Ribble Valley Borough Council

Our ref: D3.25.0688

Address: Former Genus Site (Units 1-21 Mitton Road Business Park) Mitton Road Whalley BB7 9JY

Proposal: Proposed reinstatement of previously approved phase 1 entrance, including a timber fence between phase 1 and phases 2/3

Client <b>A I Land Ltd</b>		
Project <b>Proposed Alterations to Phase I Entrance at Mitton Road Business Park Whalley</b>		
Drawing Title <b>Existing and Proposed Site Plans</b>		
Scale <b>1:500 @ A2</b>	Date <b>Aug 2025</b>	Drawn <b>LFR</b>
<b>READ DESIGN LTD</b>		
<b>102 - 09 G</b>

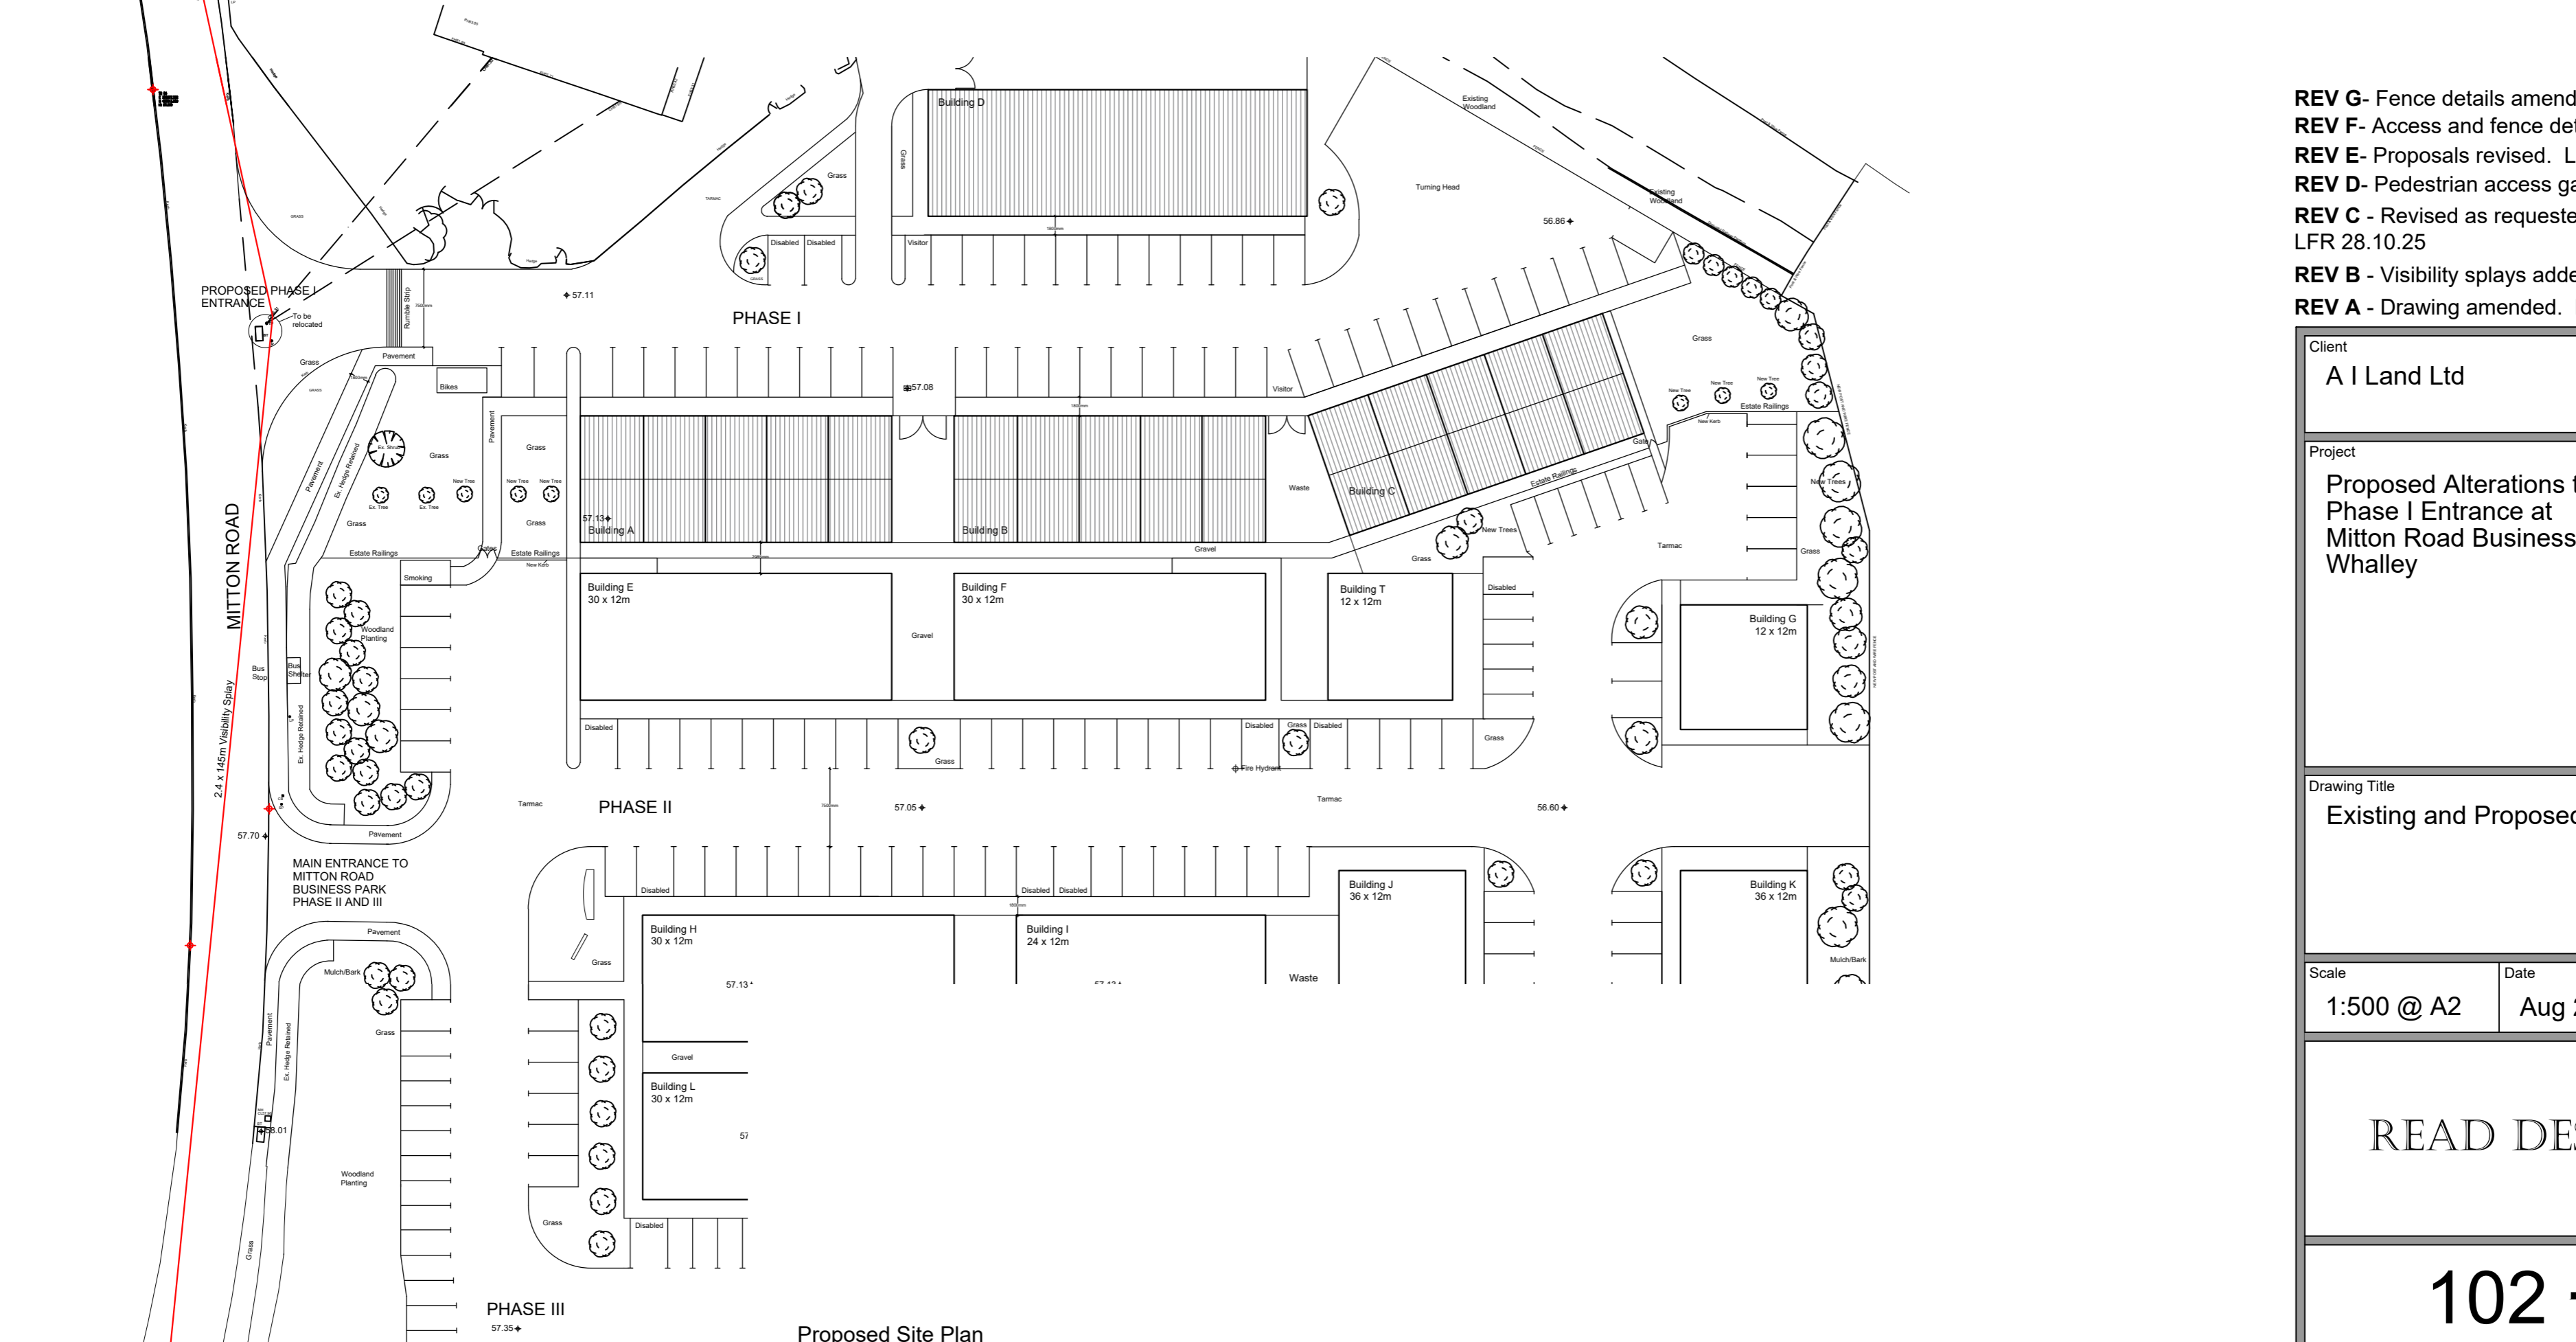
The visibility at the site access is considered acceptable. Splays of 2.4m by 90m to both sides are required and can be achieved over the highway or applicants land.

The access has been increased in width from 5.5m to 7.5m as previously requested. The radius to both sides has been increased from 6m to 12m to accommodate the longest articulated vehicles.

The proposed internal separation of Phases 1 and 2 will allow pedestrian access to be maintained, although gated, between Phases 1 and 2 for overspill car parking which is considered necessary. The gates should be unlocked or suitably managed to allow pedestrians to move between the two phases.

A new bike store is proposed for phase 1 which is supported.

1. Prior to commencement a detailed design scheme for the site access shall be submitted to the LPA and approved and be implemented within an agreed timetable. Reason: For highway safety

2. Following implementation of the new fence hereby approved, the pedestrian access shown on the approved plans shall be constructed in a bound material and maintained thereafter for pedestrians to move between all the development phases. Reason: To provide access to communal car parking areas.

3. Following implementation of the new fence hereby approved, the bike store shown on the approved plans shall be provided and maintained thereafter for bicycle parking. Reason: To support sustainable travel.
